## **Timber Ridge West Comment Review Responses April 2019**

Review comment responses from latest submission are summarized as follows:

### PROPOSED DRAINAGE MAP

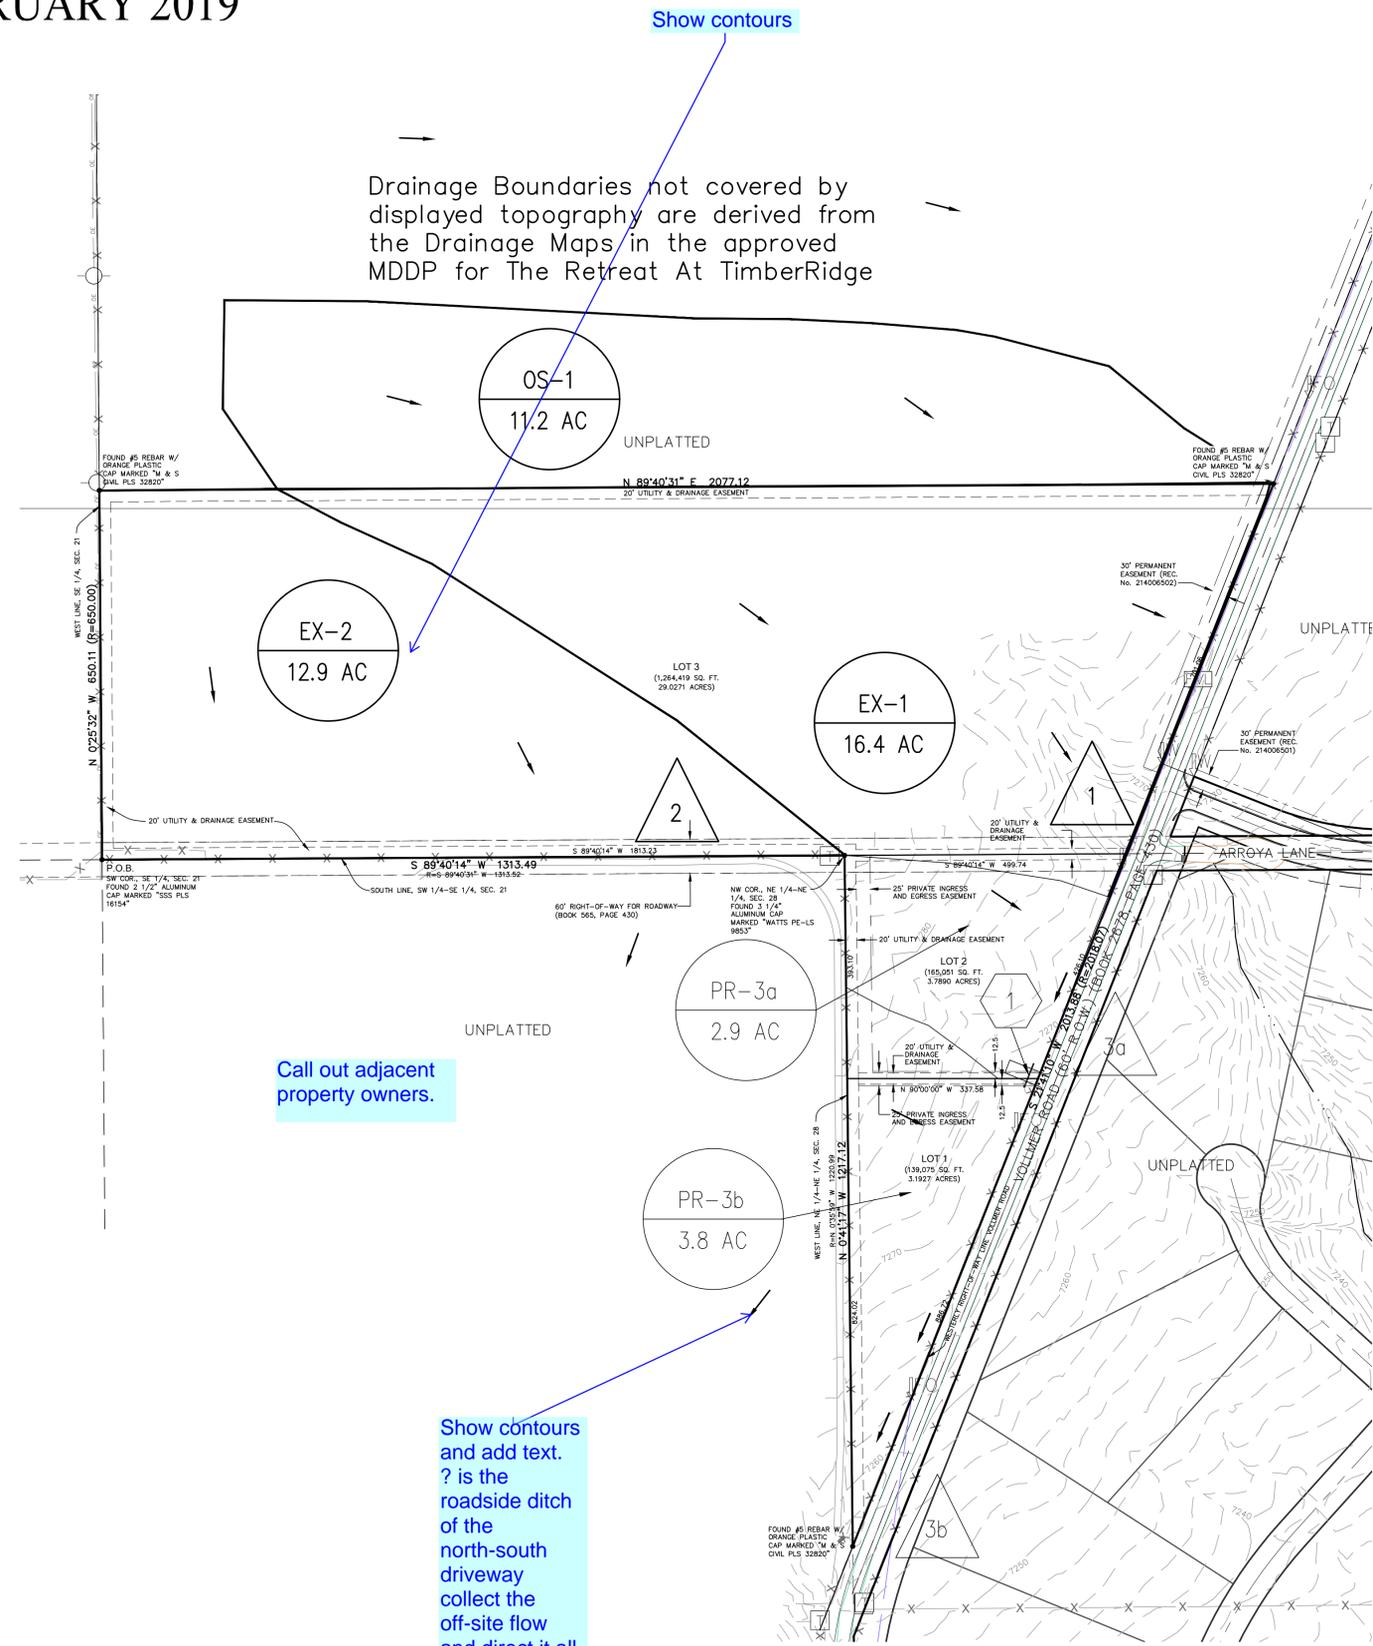
### **PCD Project Manager Drainage Report Redlines – March 7, 2019**

The requested, primarily minor, modifications to the drainage report have been made and updated report uploaded.

Timber Ridge West

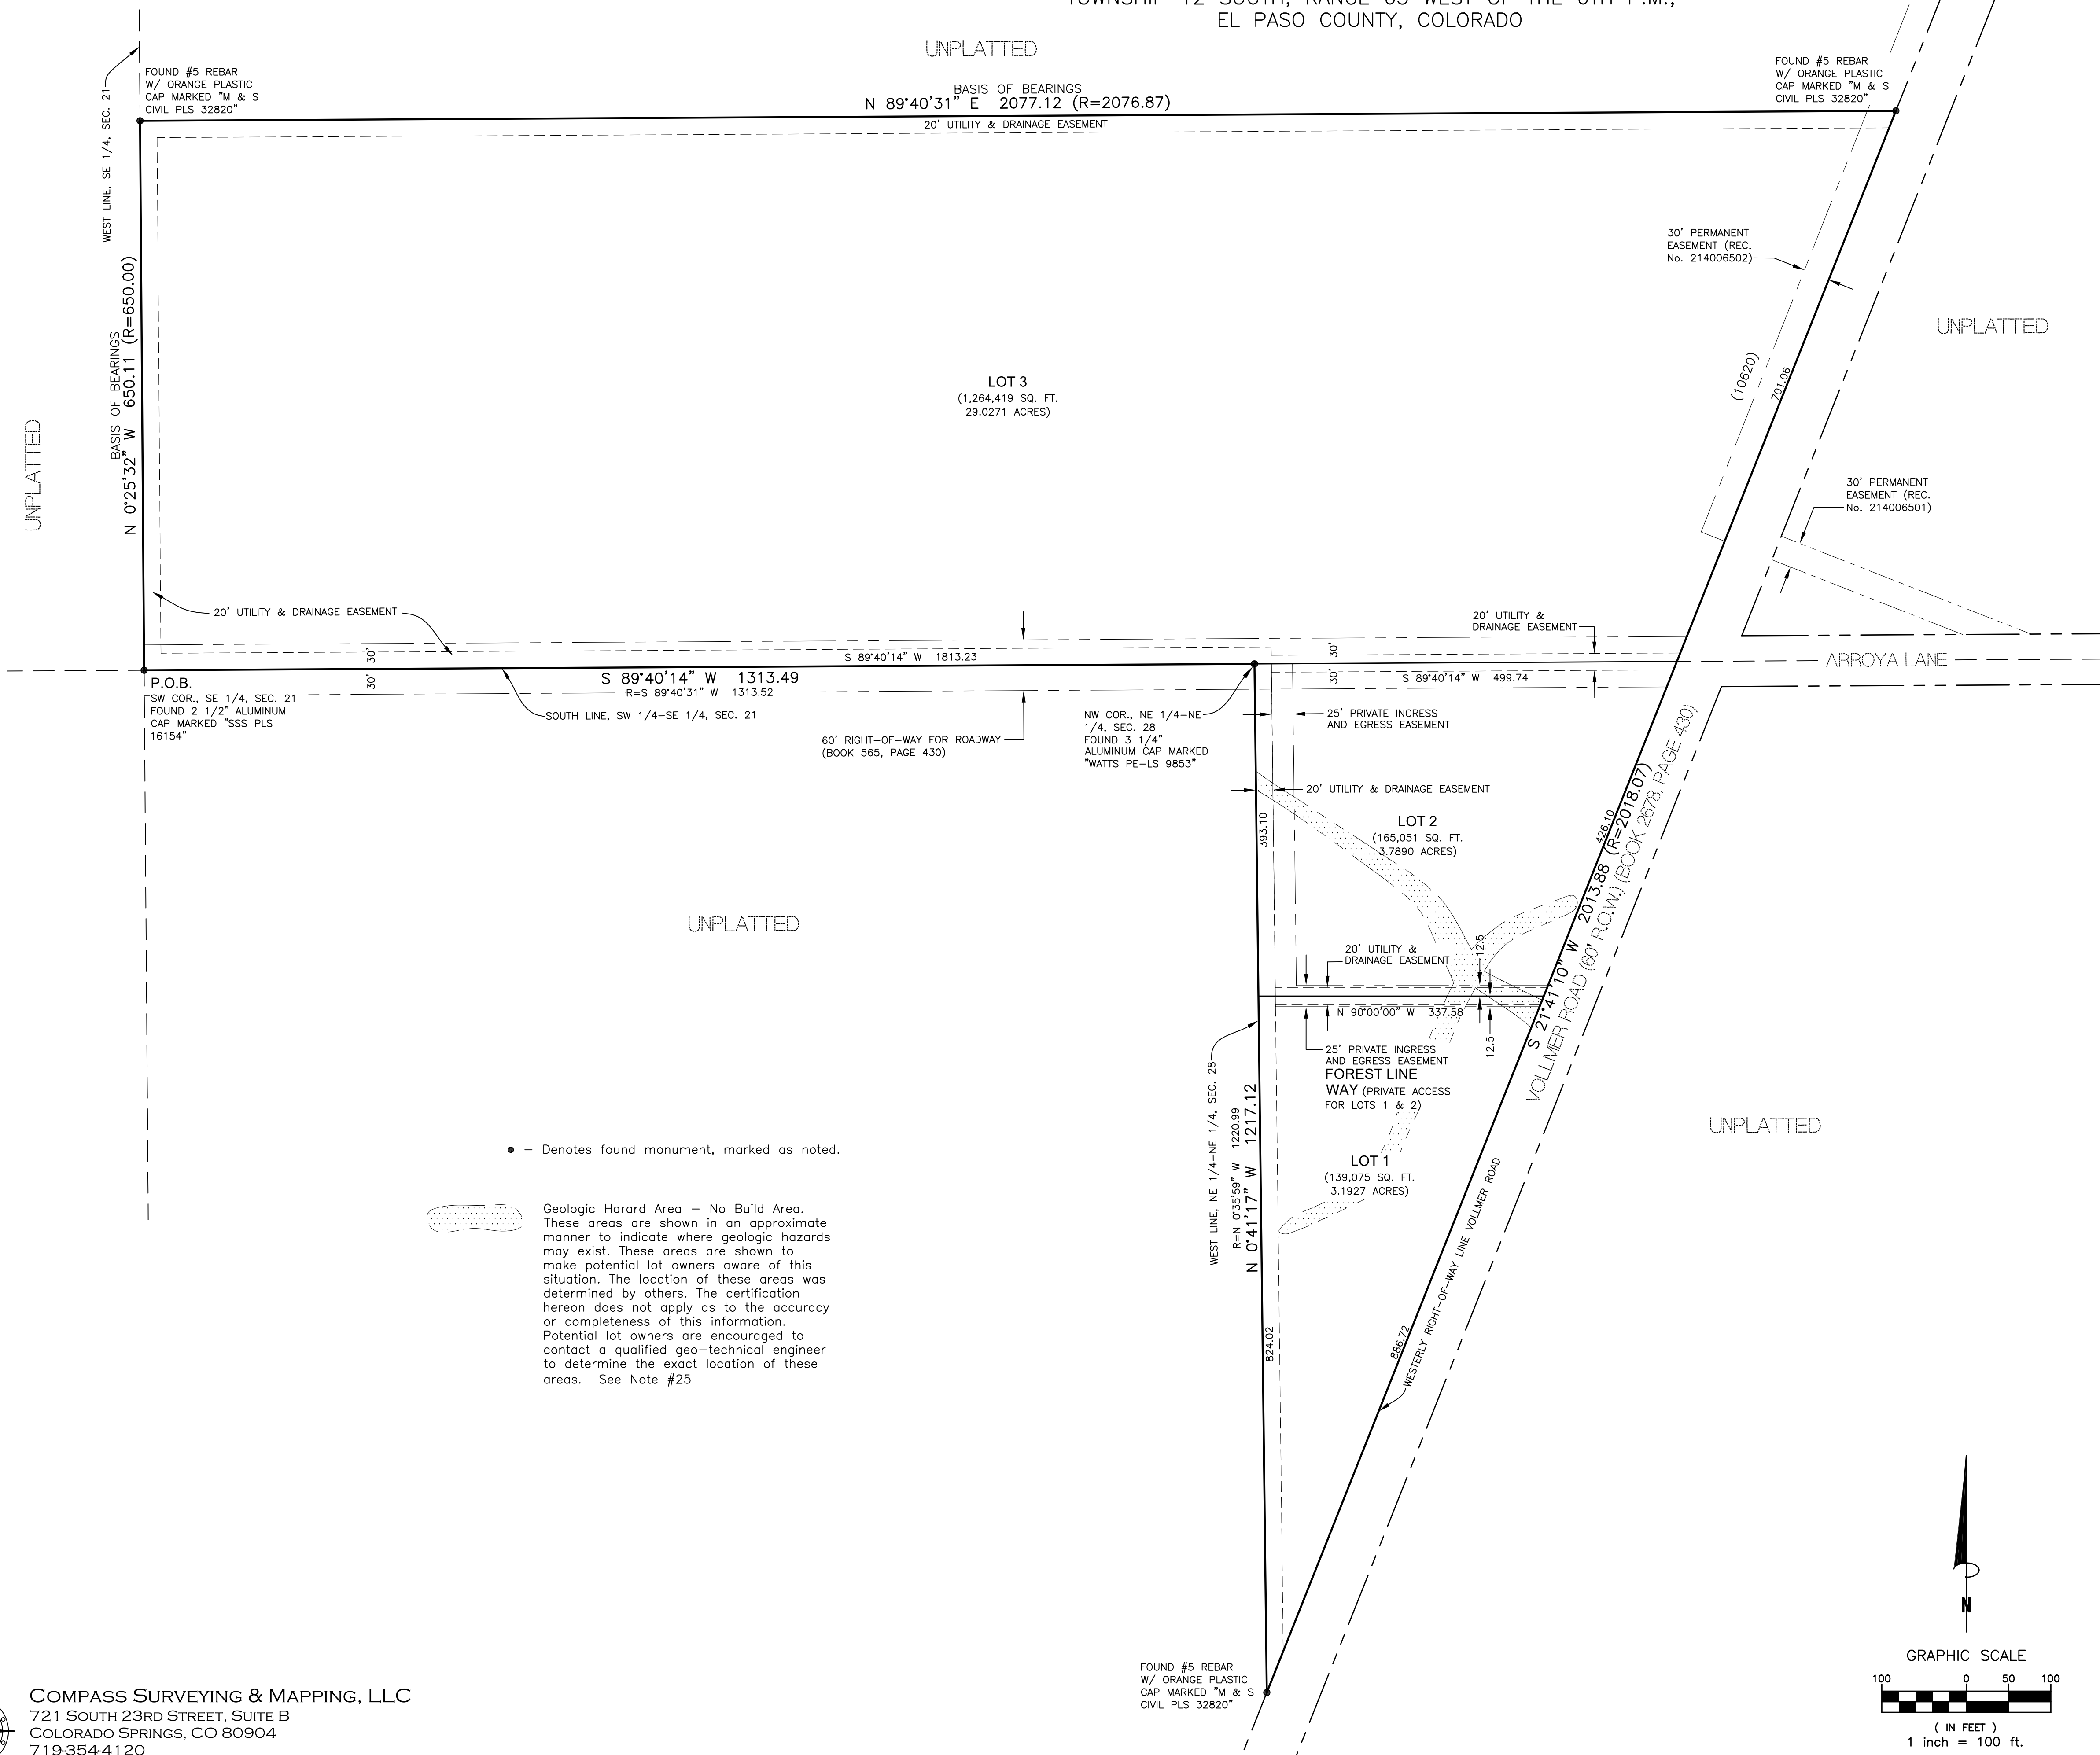
**Pikes Peak Regional Building Department – March 7, 2019**

As requested the private driveway access for Lots 1 and 2 will be given a private access name. The preliminary name, pending submittal to and approval by 911, is shown on the final plat as 'Forest Line Way'.
